## **COUNTY COUNCIL'S RESPONSE TO CONSULTATION ON THE FOLLOWING DEVELOPMENT PROPOSAL**

**Application no:** 21/02278/F

**Proposal:** Development within Use Classes E (g) (i), and/or (ii), and/or (iii), and/or B2 and/or B8 and Associated Works including Access and Parking

**Location:** Oxford Technology Park, Langford Lane, Kidlington

content : BUILDING 4A & 4B PROPOSED CYCLE LOCATIONS

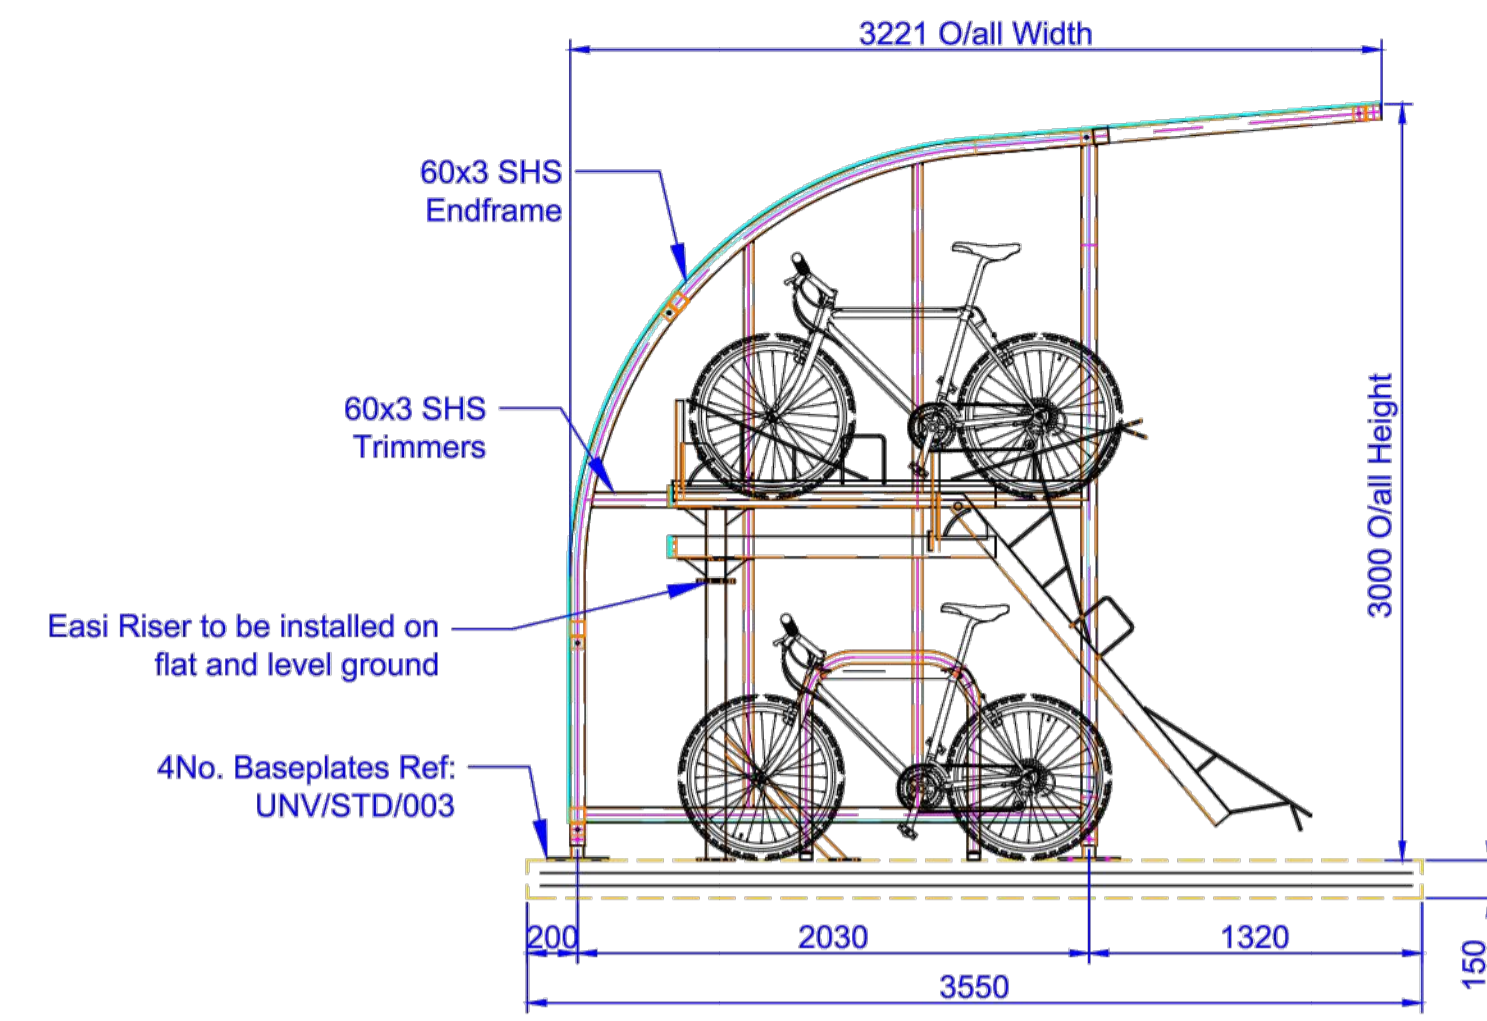
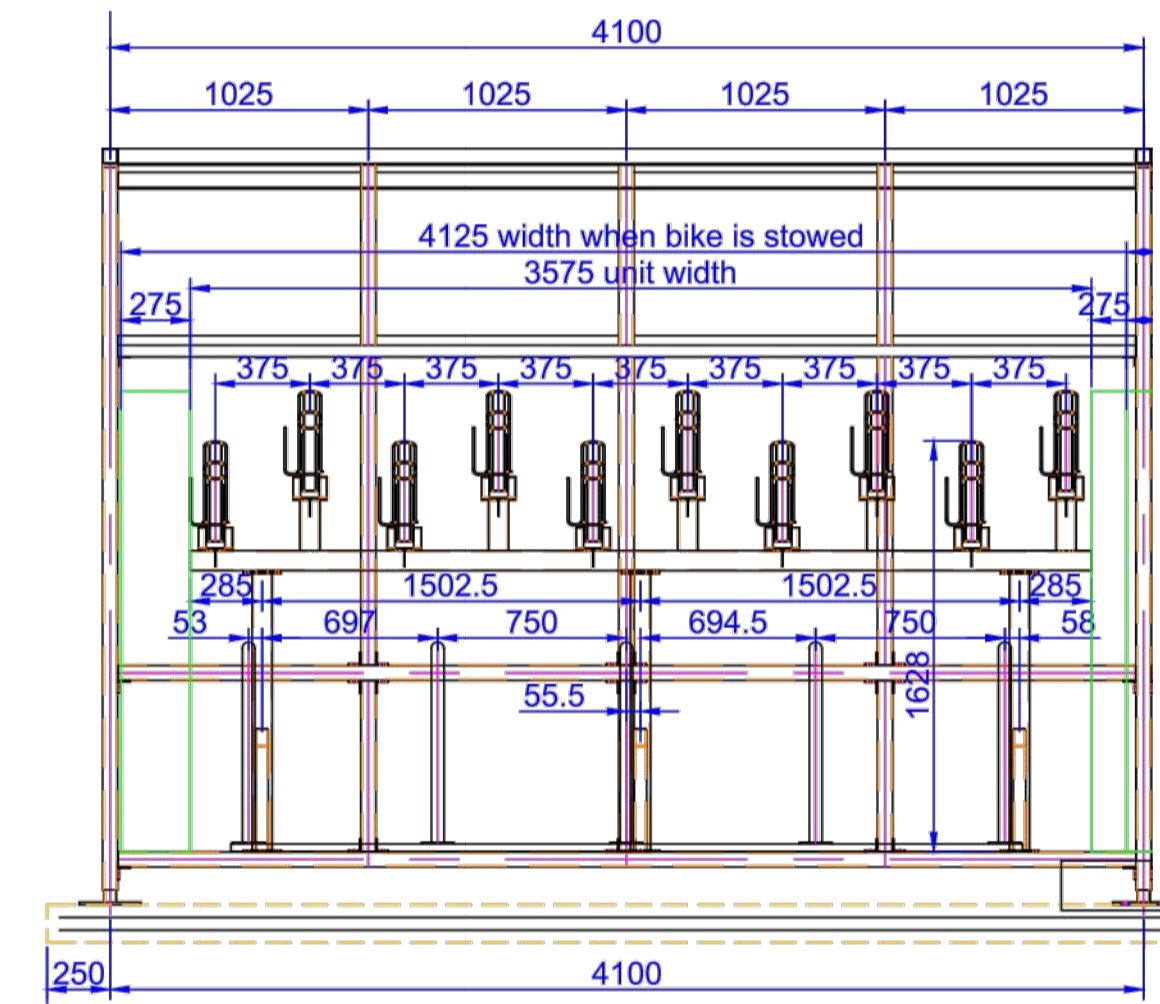
The level of cycle parking being proposed is close to the county council's recommended standards. However, usage of those spaces should be monitored with additional cycle parking provided if / when necessary.
